CITY OF ALBUQUERQUE

PLANNING DEPARTMENT – Development Review Services

**RE: Desert Sands Subdivision
Drainage Report, and Grading and Drainage Plan
Engineer's Stamp Date 4-27-2016 (File: N09D014)**

DESIGN REVIEW COMMITTEE	CITY ENGINEER APPROVAL	LAST DESIGN UPDATE	MO./DAY/YR.	MO./DAY/YR.
CITY PROJECT NO.	ZONE MAP NO.	SHEET	OF	
		2	6

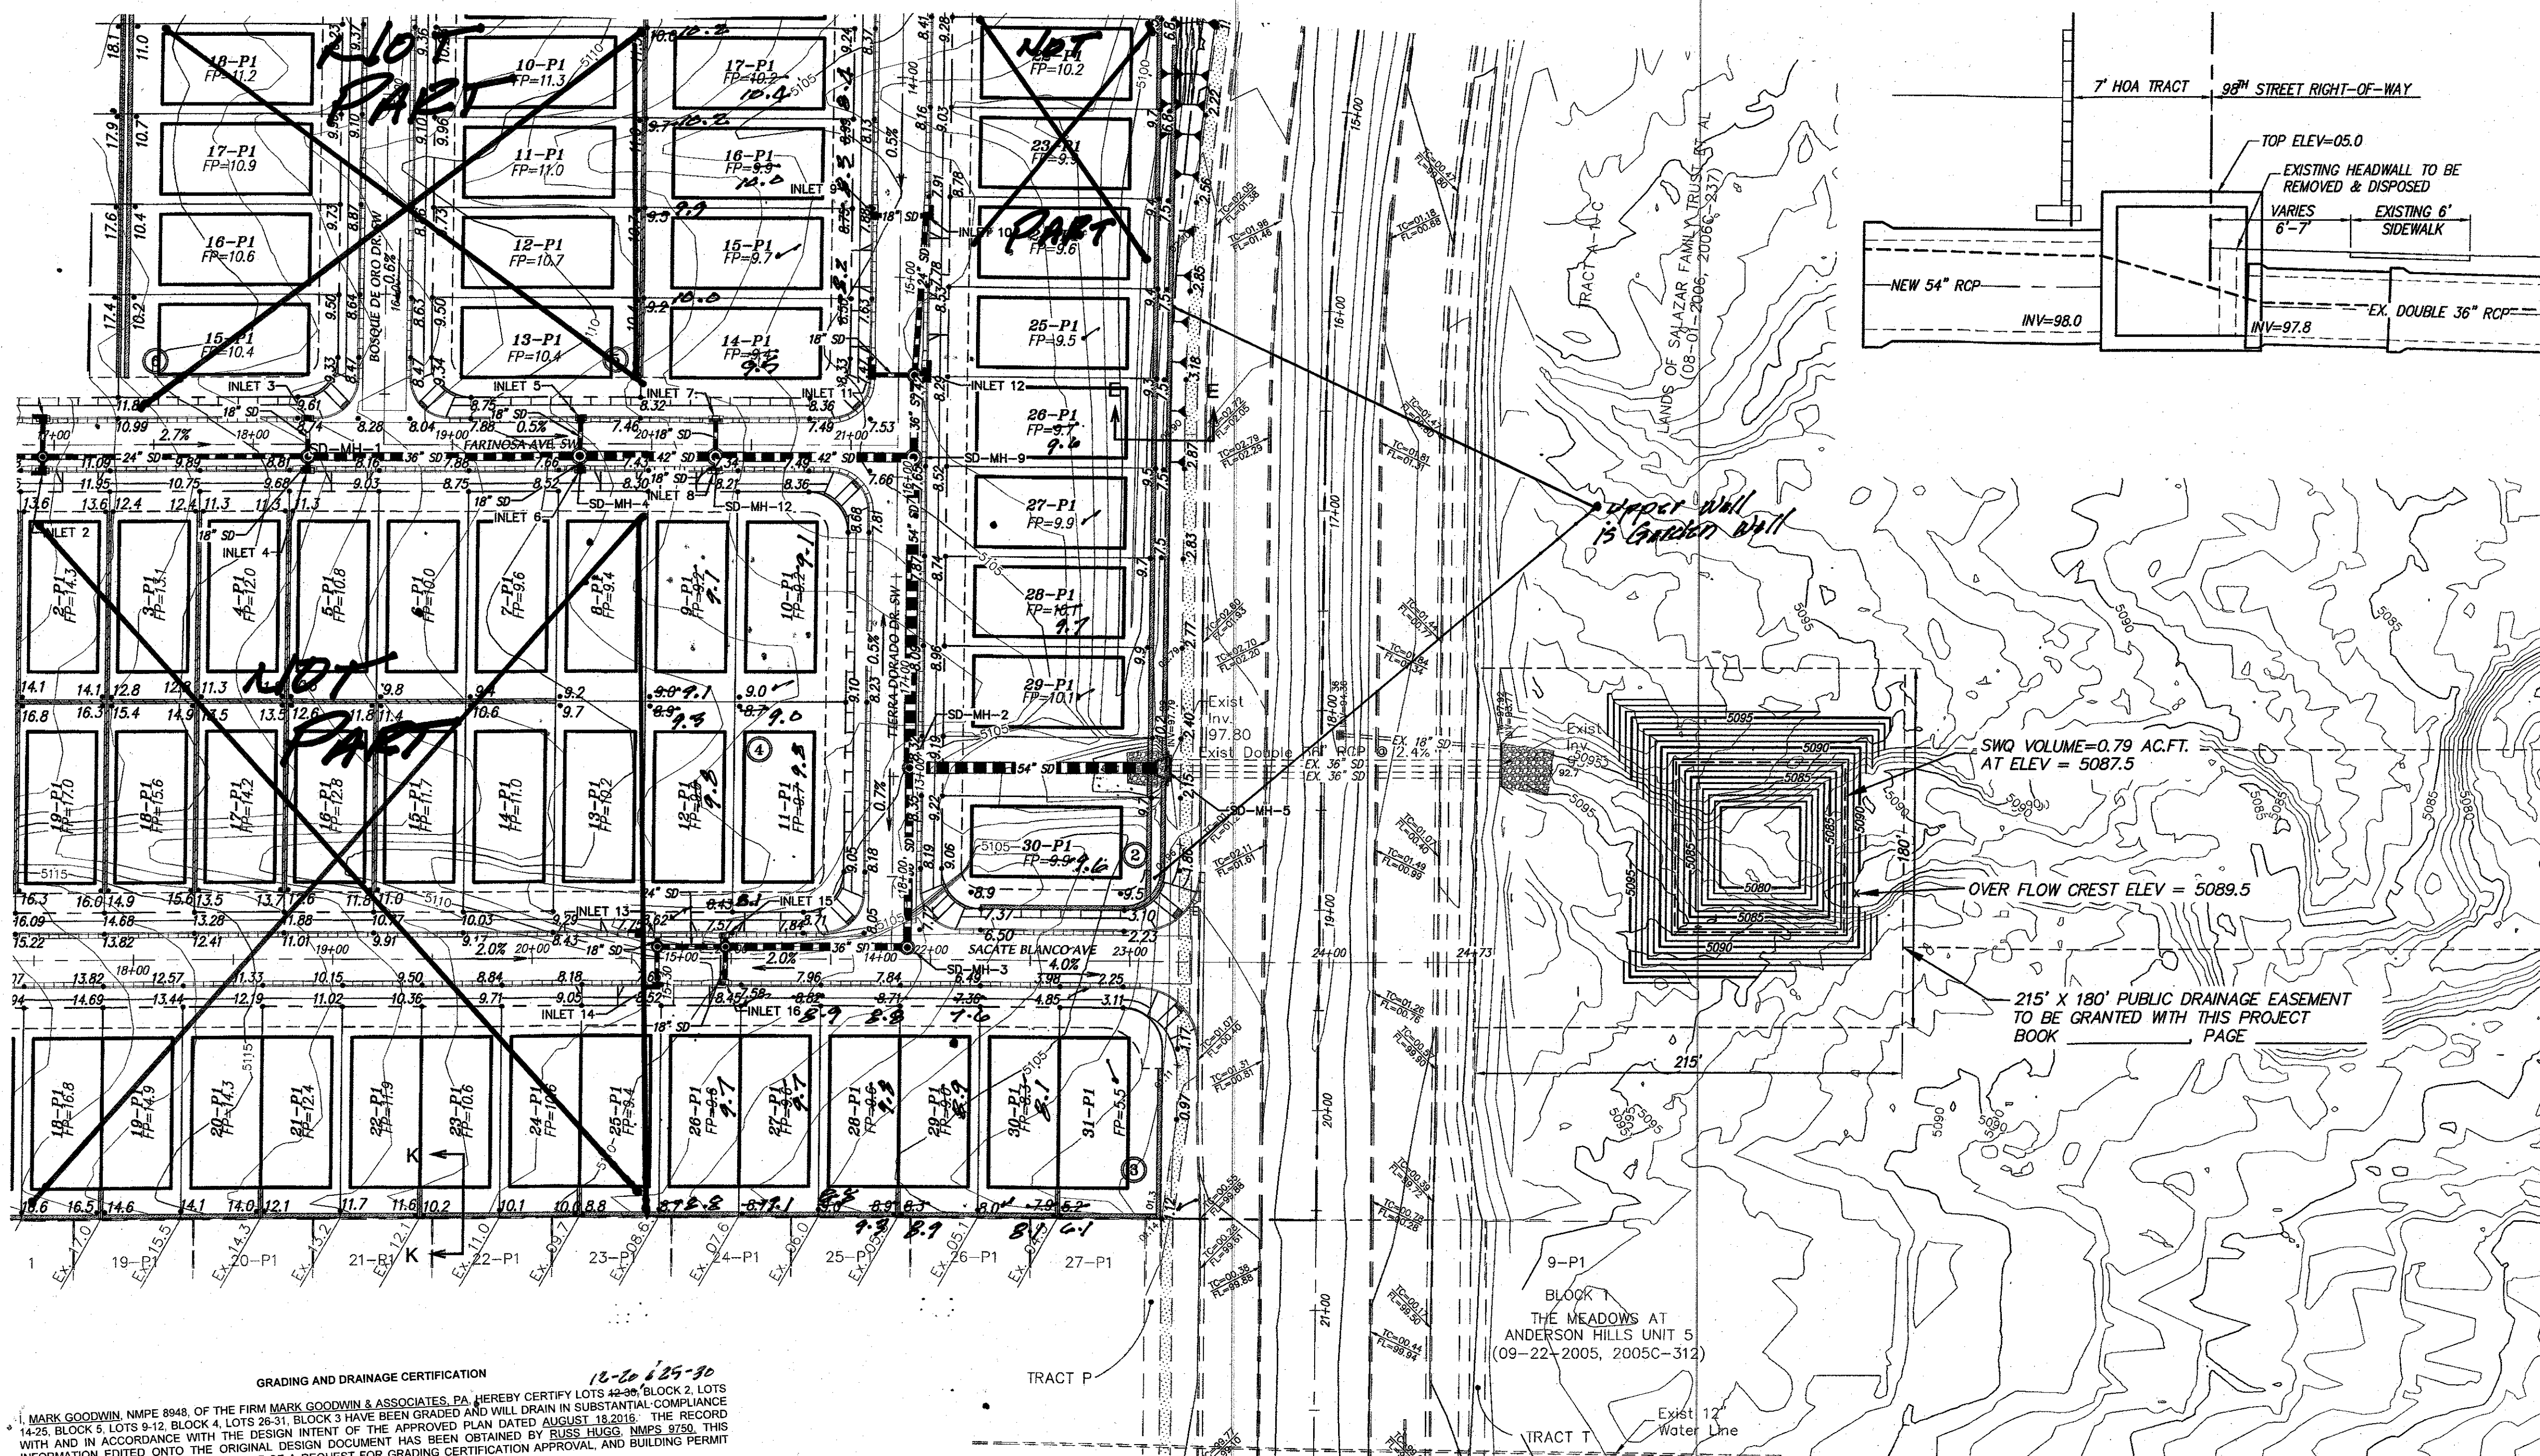
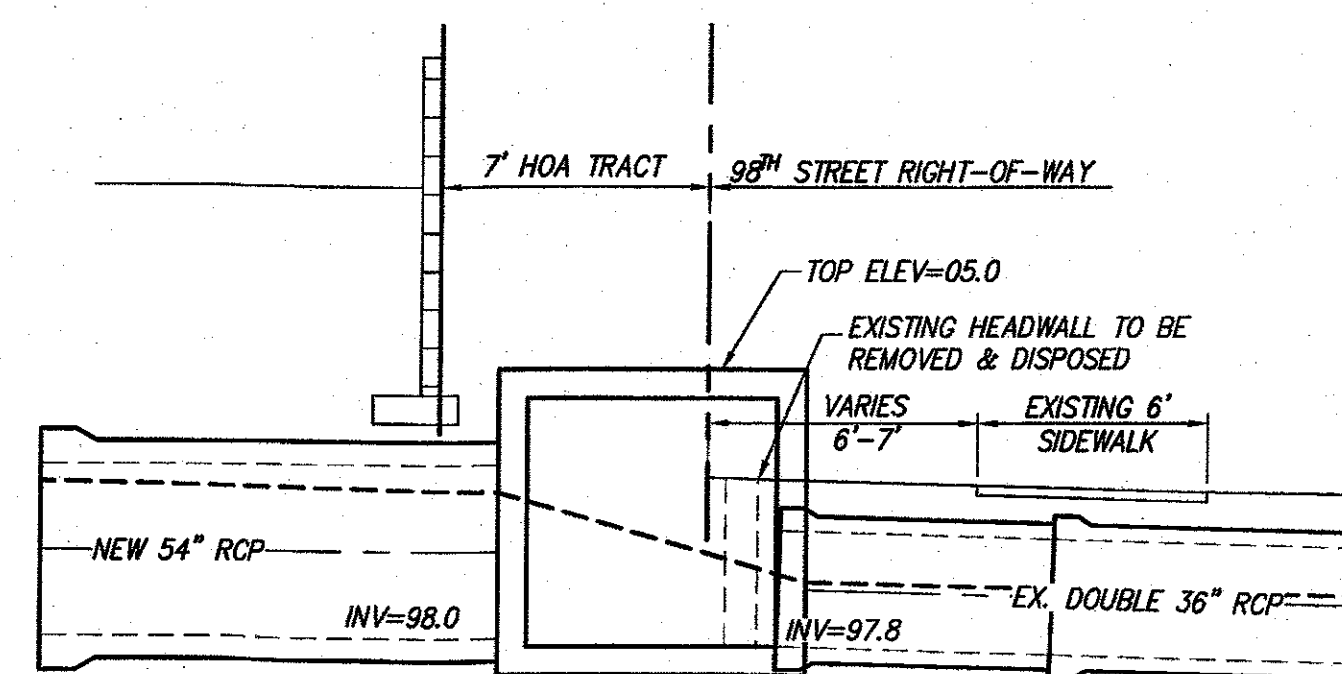
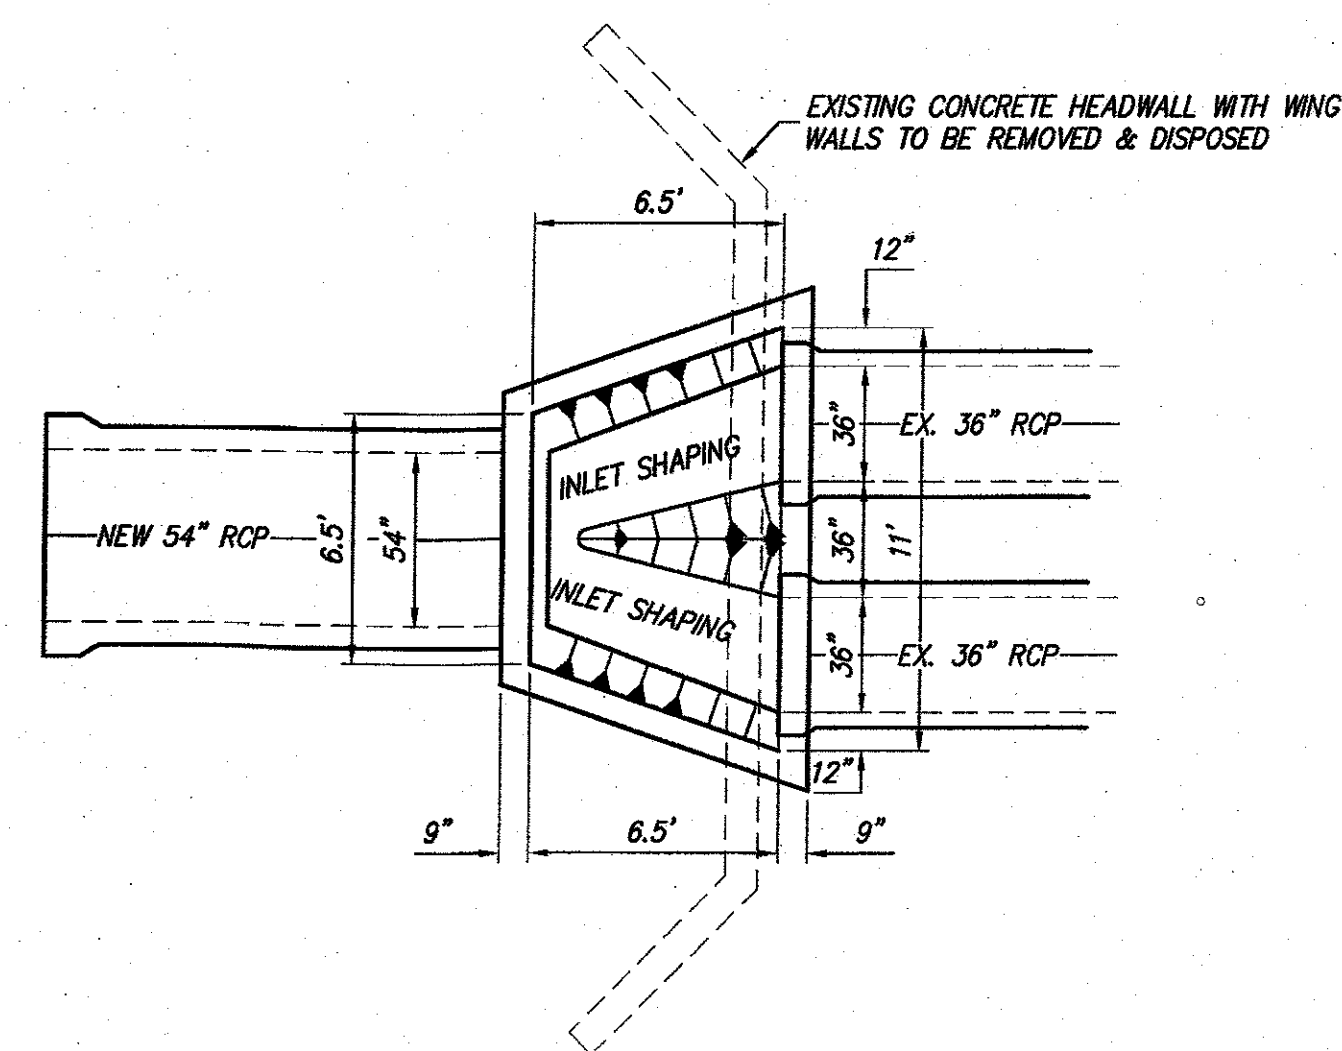
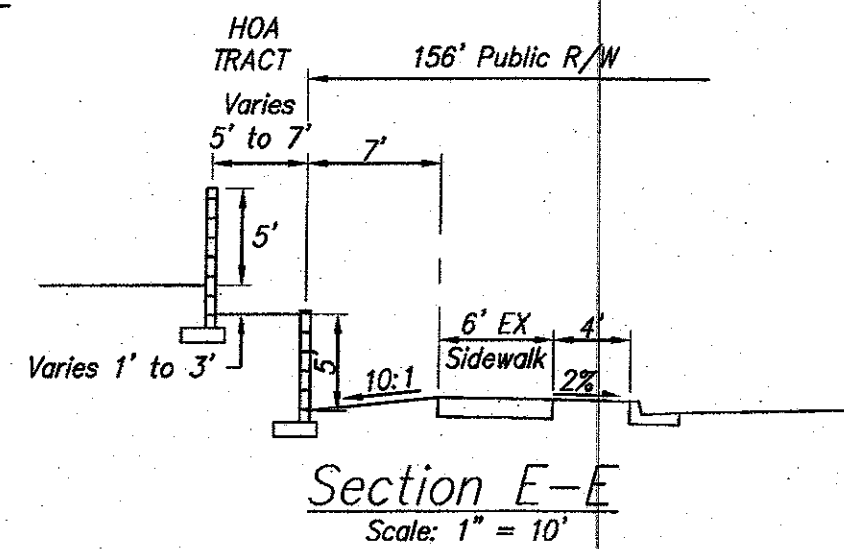
1. Retention pond was designed for the 100 yr-10 day storm; however, show the 100-yr 10-day storm volume on Sheet 5 (Volume shown is for the 6-hr storm). Similarly on Sheet 2, Section D-D, volume shown is for the 6-hr storm. What storm is used for the elevation shown – the 10day or 6 hr? Label as Max WSEL and indicate the storm. See DPM for freeboard requirements.

9. Section Cuts on Sheet 2 show slopes can be up to 2:1. Slope protection is required. DPM Committee has determined new slope protection requirements for updated DPM and can be provided to you if you are interested in using them.

12. Section H-H, Sht. 2, shows that SW culverts have reverse flow. Indicate so with a note. On construction drawings a note should state that the lip shown on the standard drawing is to be omitted (due to the reversal of flow). Show Flowline Elev. on both ends of the culverts. Also, multiple culverts in a series have been discouraged due to failures. Can the number of culverts be reduced?

Section K-K

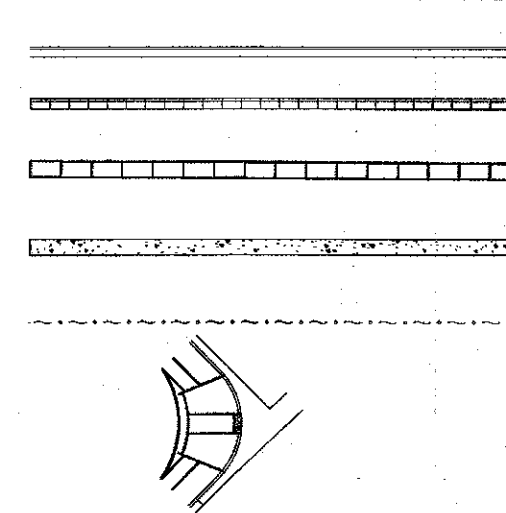
b. Retaining wall along southern boundary is shown right up against the existing screen walls and there may be constructability issues. Provide a section cut along the southern boundary. Section K-K has been added to sheet 3 of the G&D and note 12 has been added to sheet 1 to protect the wall on the south and the sidewalks on the west and east.
